May 4, 2022

**Re: CARMEL APARTMENTS B**  
**7310 Carmel Ave. NE**  
**Traffic Circulation Layout**  
Architect's Stamp 03-03-2022 (C19-D069)

Based upon the information provided in your submittal received 04-13-2022, the above referenced plan cannot be approved for Building Permit until the following comments are addressed:

AS-2.0

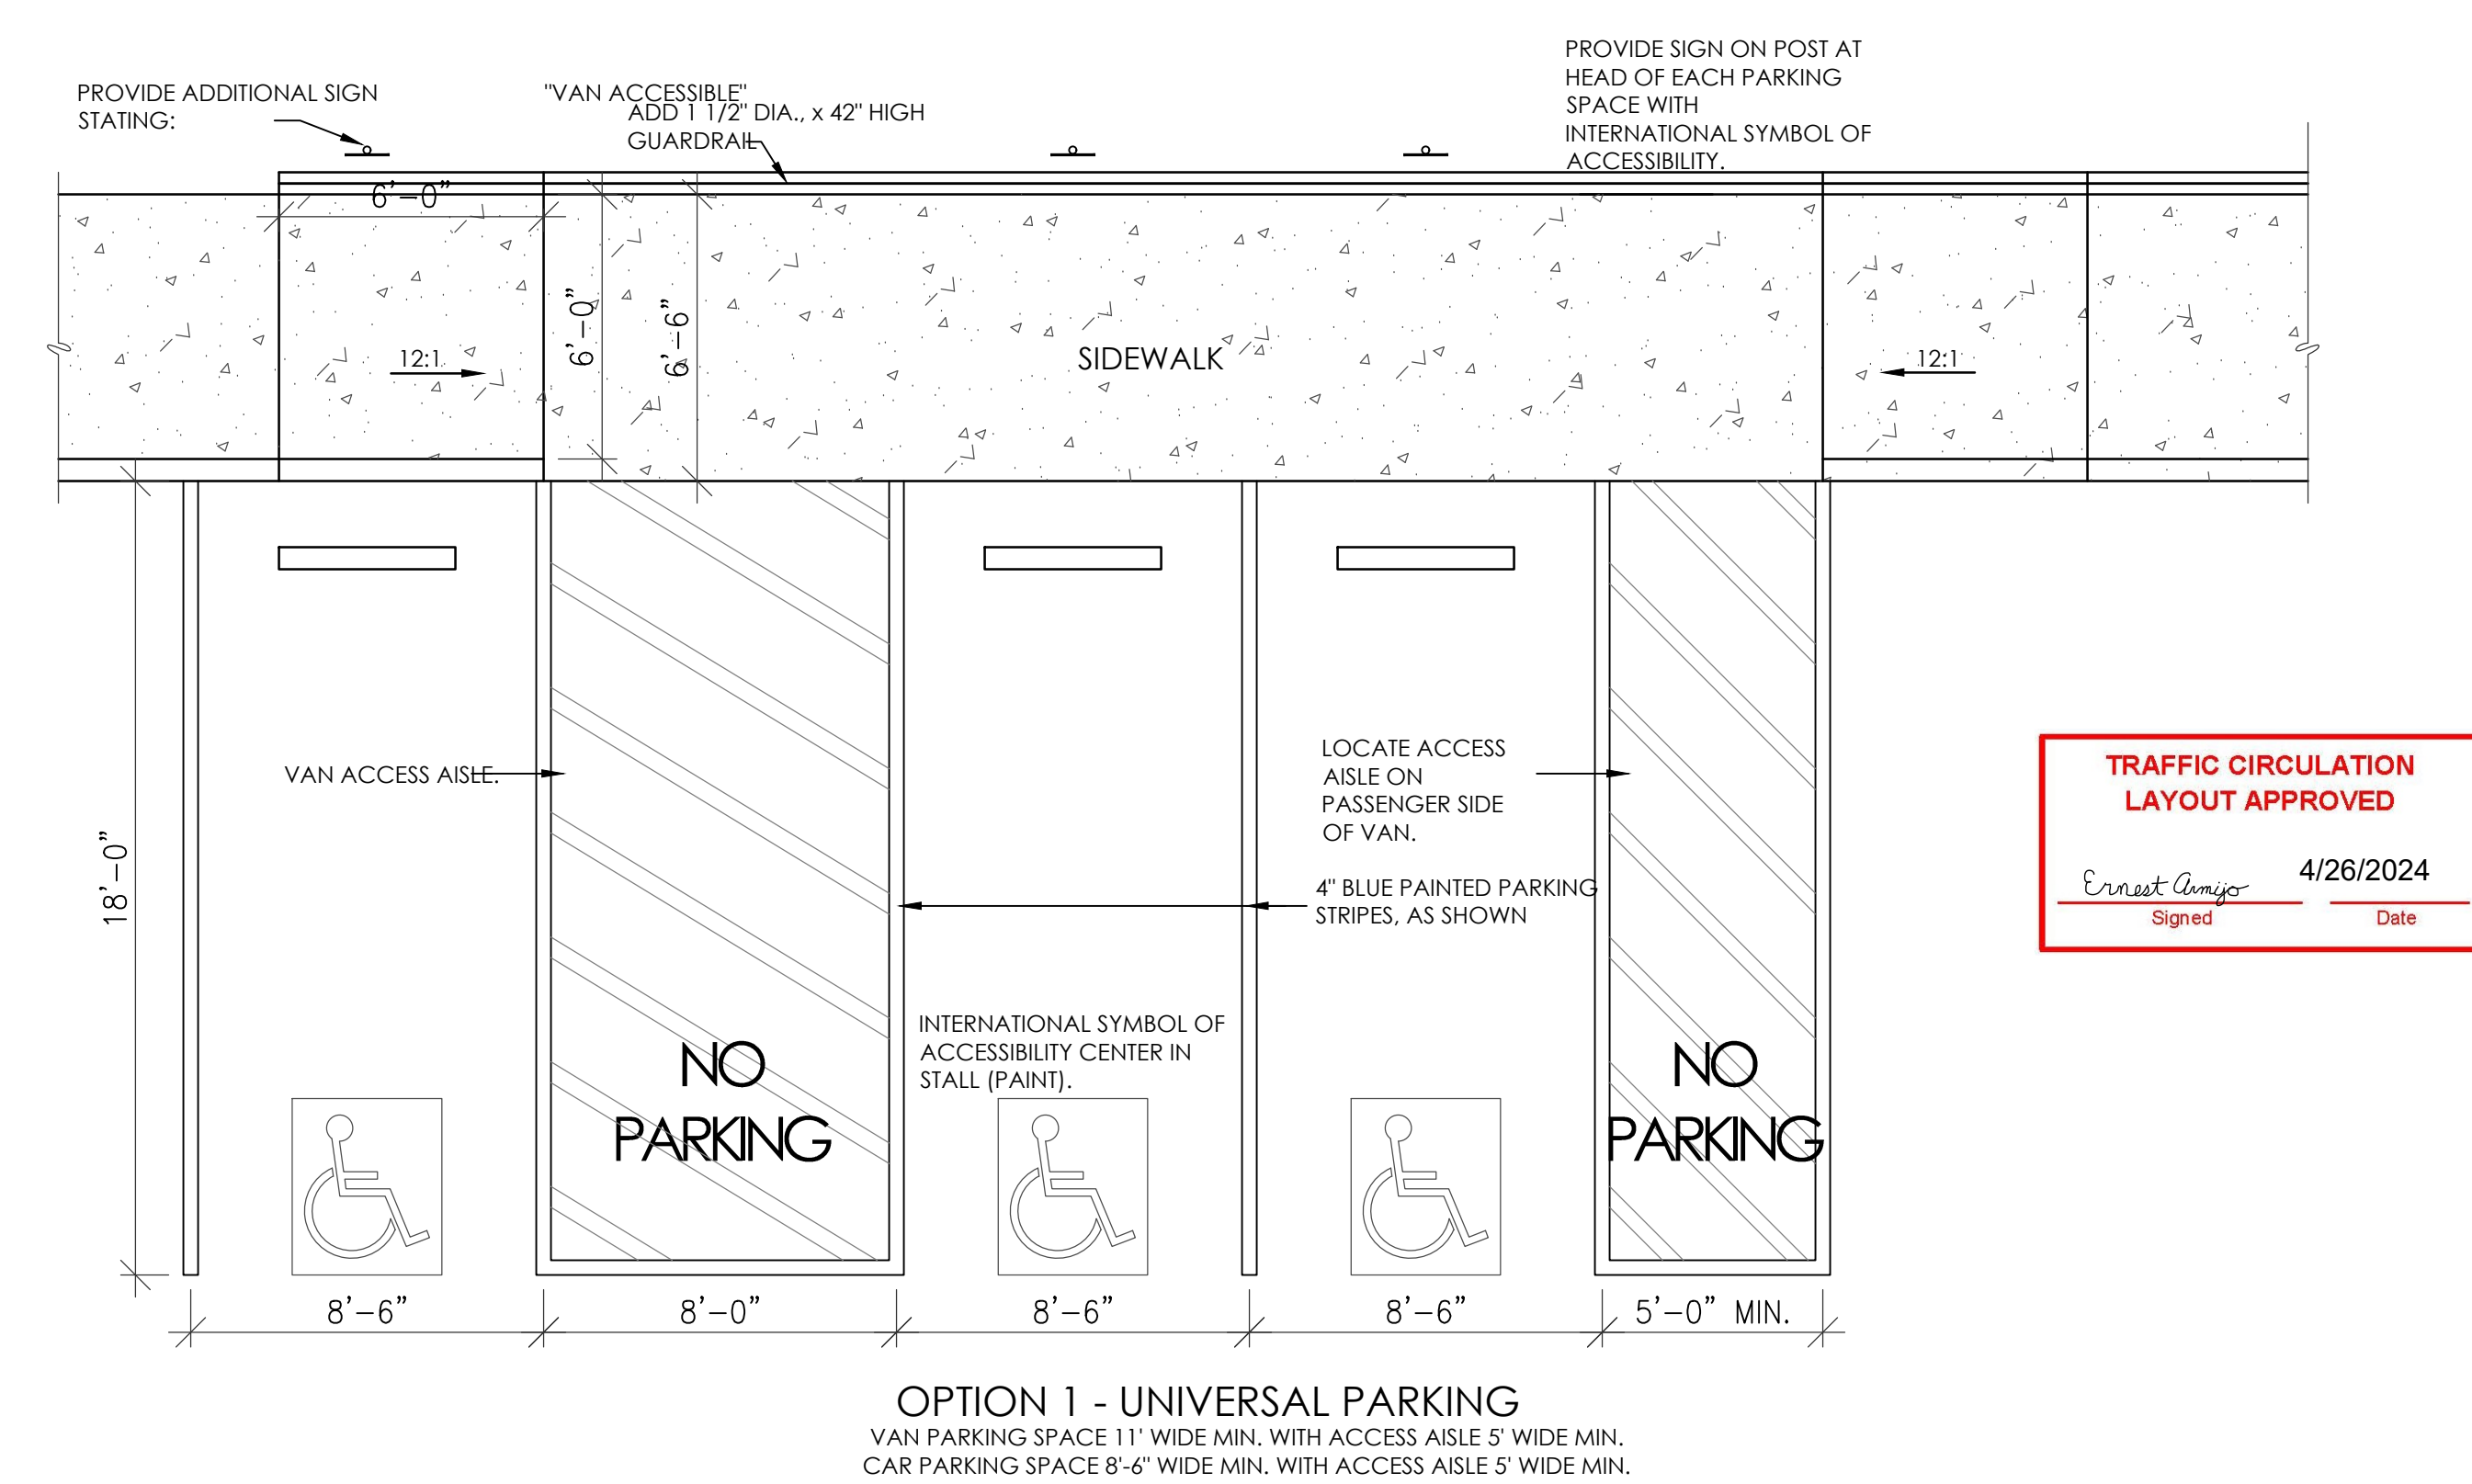
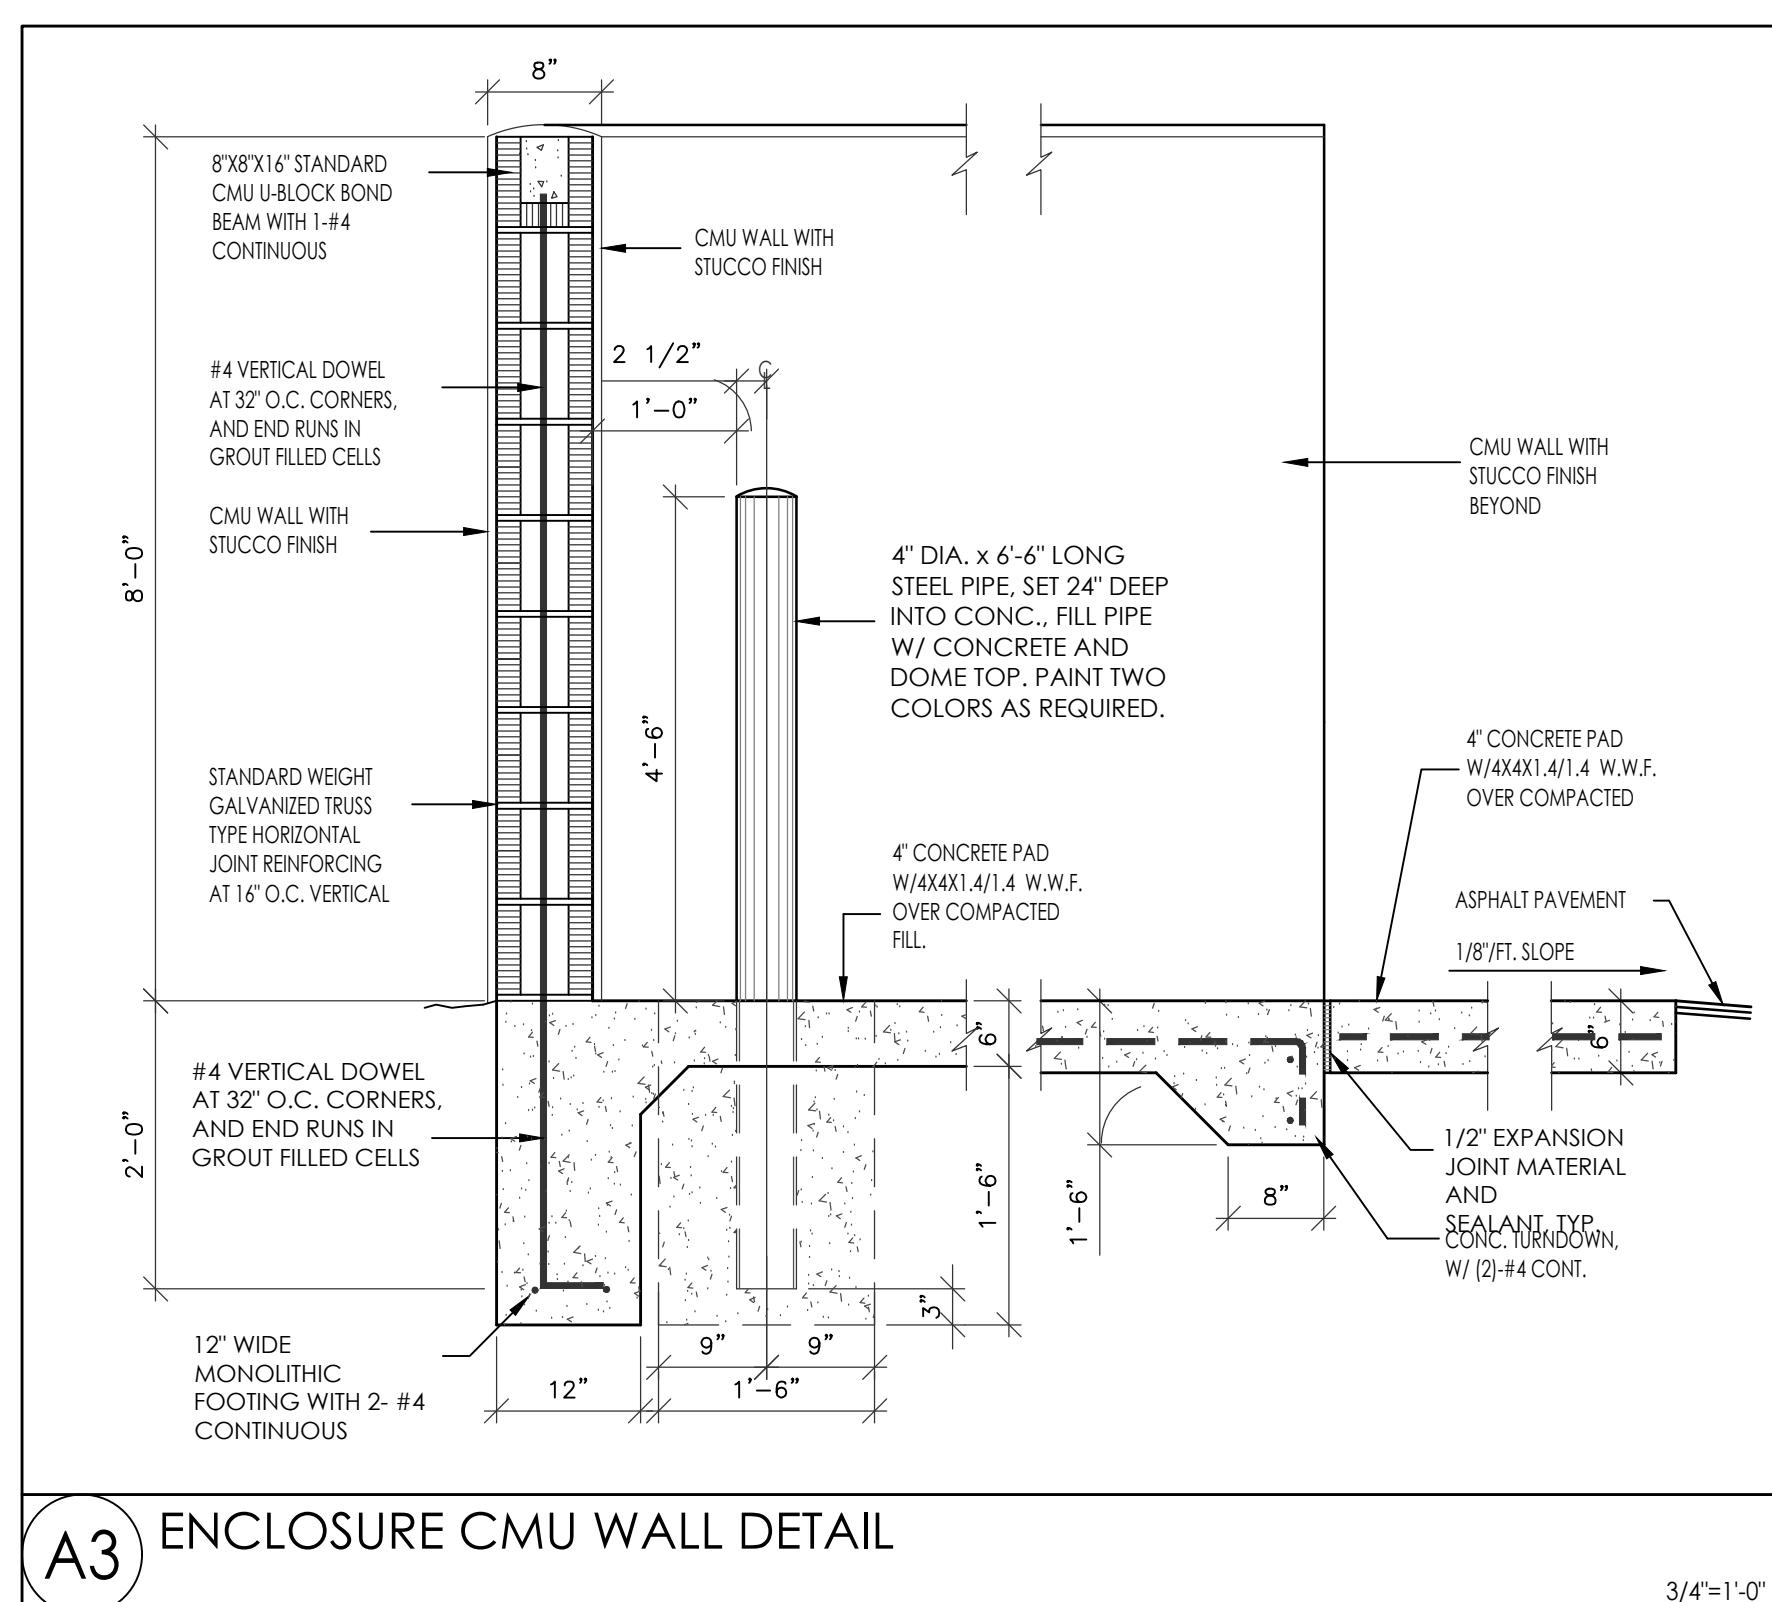
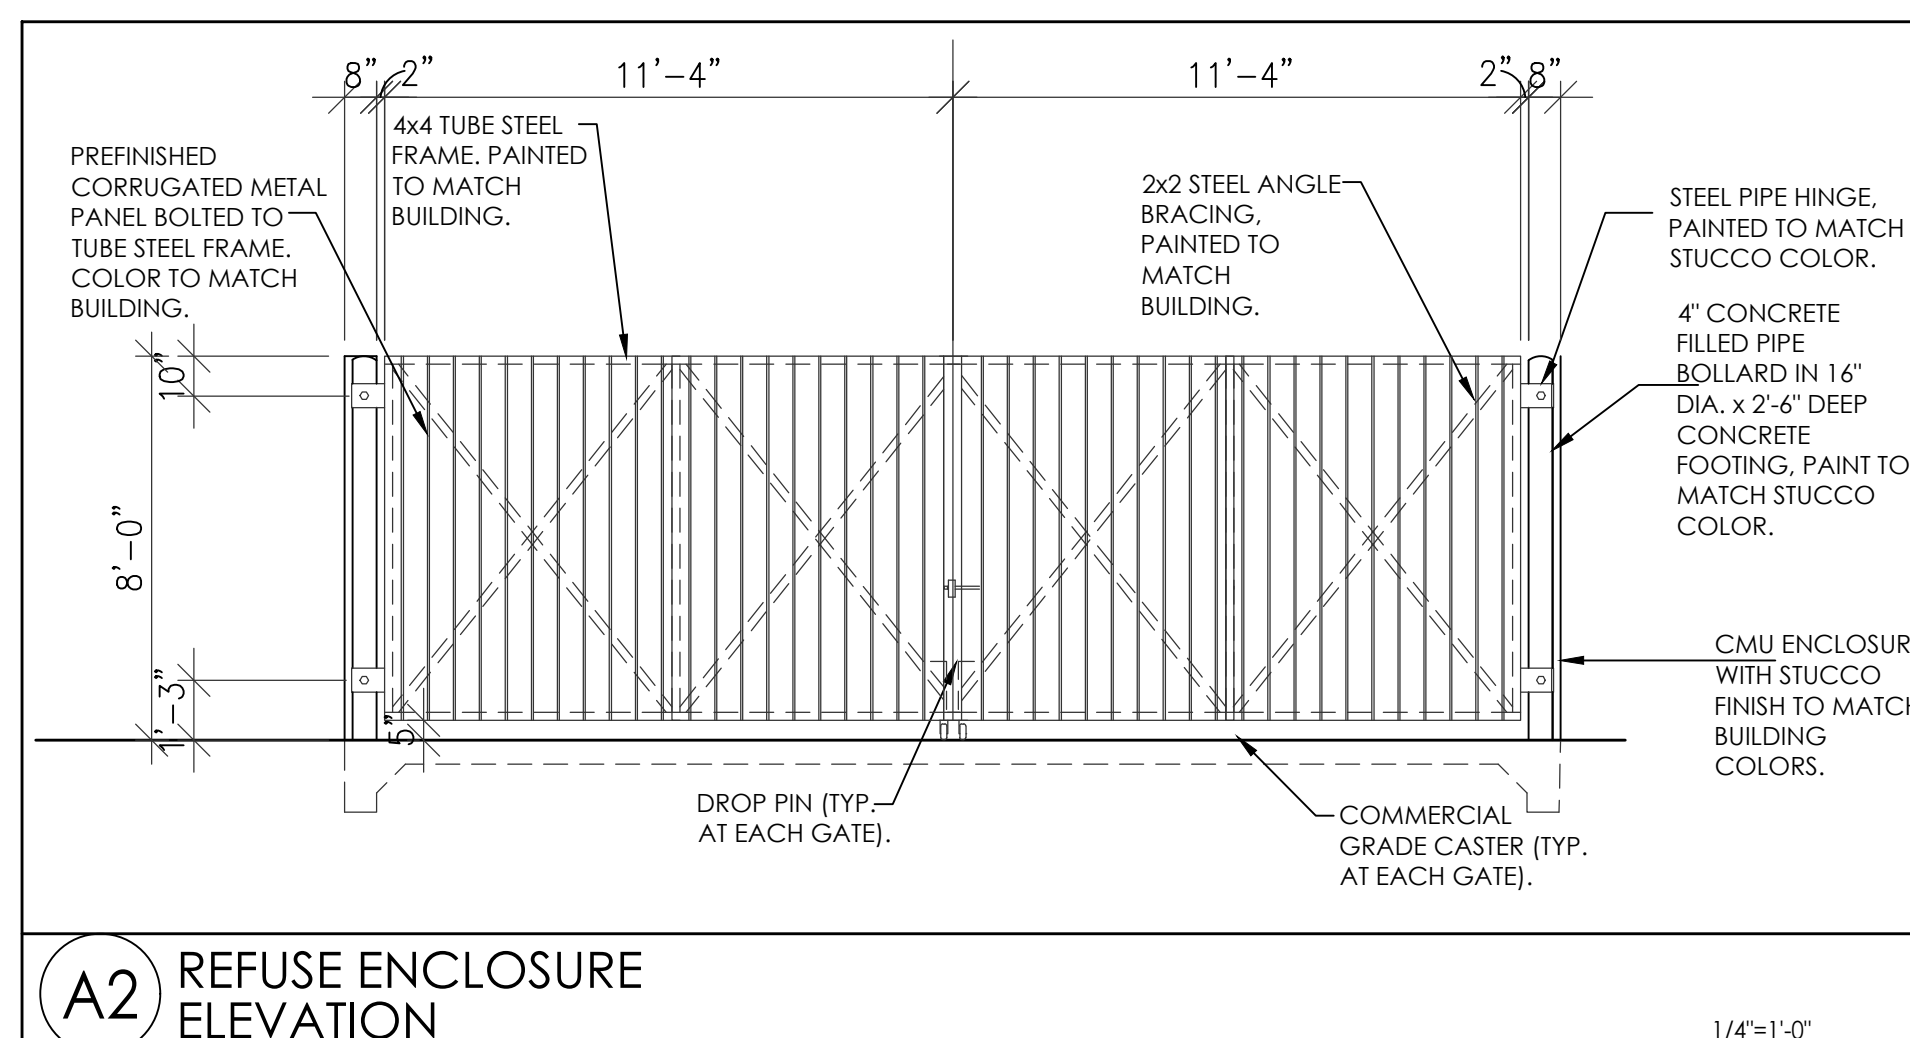
7. **Detail A4:** Paint Bollards yellow.
  8. **Detail A8:** Note 50:1 max on top of sidewalk and 12:1 max for taper. Stall widths are 8'-6" not 8'-0"-6" please adjust text.
